# Submissions Report

SSD-72891212

57-61 Archer Street and 34 Albert Avenue,  
Chatswood

July 2025

Sheet title
SITE PLAN

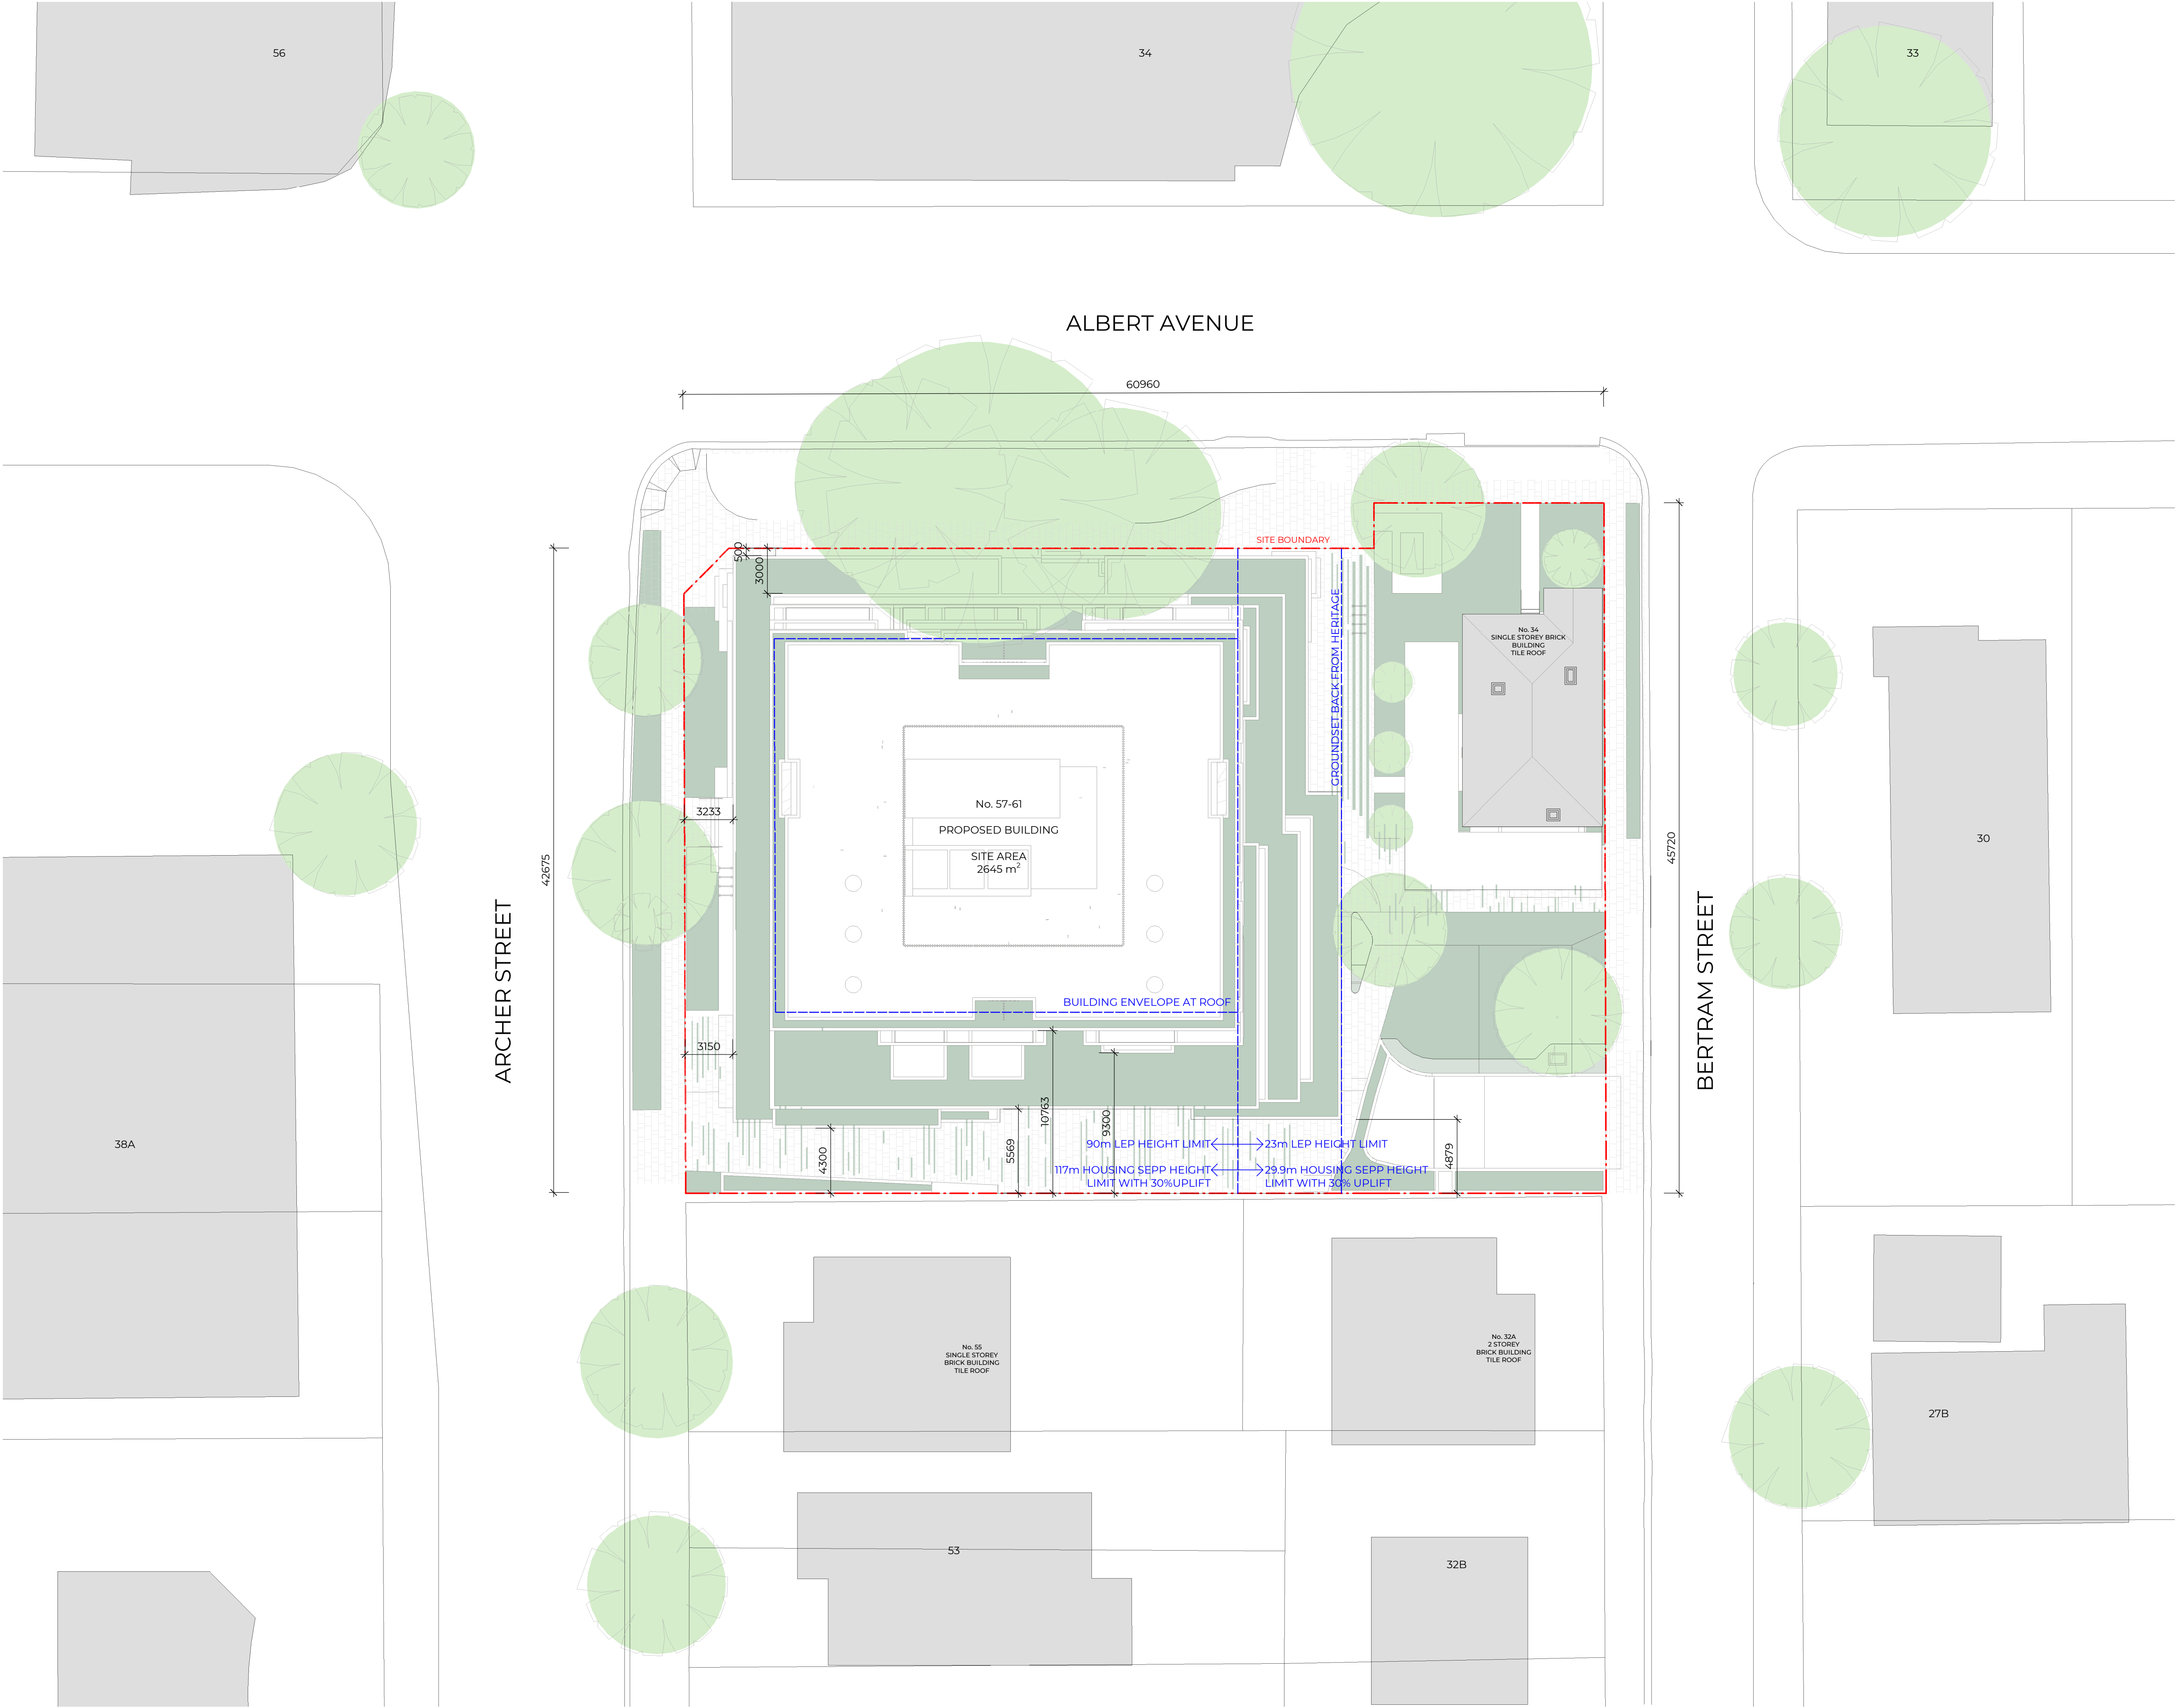
<b>3. Electrical substation</b>	
a) The Department notes the proposed substation is located in a physically and visual prominent location. Provide an analysis of alternative substation locations, which have/can be considered and demonstrate that the final proposed substation location appropriately responds to the following:  i. Visual/heritage impacts, regarding the proximity to the retained heritage item and pedestrian entrance/s.	<p>It is noted that the substation location is determined by Ausgrid's requirements for access to the substation. The design of the substation has been designed in correspondence to this limitation.</p> <p>Adequate separation has been provided between the substation and the heritage building. High quality landscaping is also provided around the perimeter of the substation to enhance the visual quality of the infrastructure.</p> <p>As indicated in the Heritage Impact Statement (HIS) (<b>Appendix AH</b> of the EIS Package) submitted, the location of the substation has been carefully considered and is located in the existing hardstand parking area forward of the heritage</p>

SUMMARY OF ISSUE RAISED	RESPONSE
	<p>building, which will ensure that no significant fabric is disturbed, and will be screened by new landscaping.</p> <p>The HIS has also indicated that the current primary views to and from the heritage item would be maintained. It confirms that steps have been undertaken to reduce the impact of the proposed works on the setting of the heritage on the site and in the vicinity.</p>
<p>ii. Maintaining clear pedestrian sightlines</p>	<p>As mentioned above, adequate separation has been provided between the substation, heritage building and the proposed tower. The proposal also provides clear pedestrian pathways in the east-west and north-south directions. The substation will therefore maintain clear pedestrian sightlines.</p>
<p>iii. Safety and crime prevention, to avoid creating areas of concealment or attract anti-social behaviour.</p>	<p>As indicated in the CPTED Report (<b>Appendix U of the EIS Package</b>) submitted, the proposal will incorporate adequate lighting, CCTV and appropriate signage to ensure that surveillance opportunities are maximised and the potential for crime is kept to a minimum.</p>
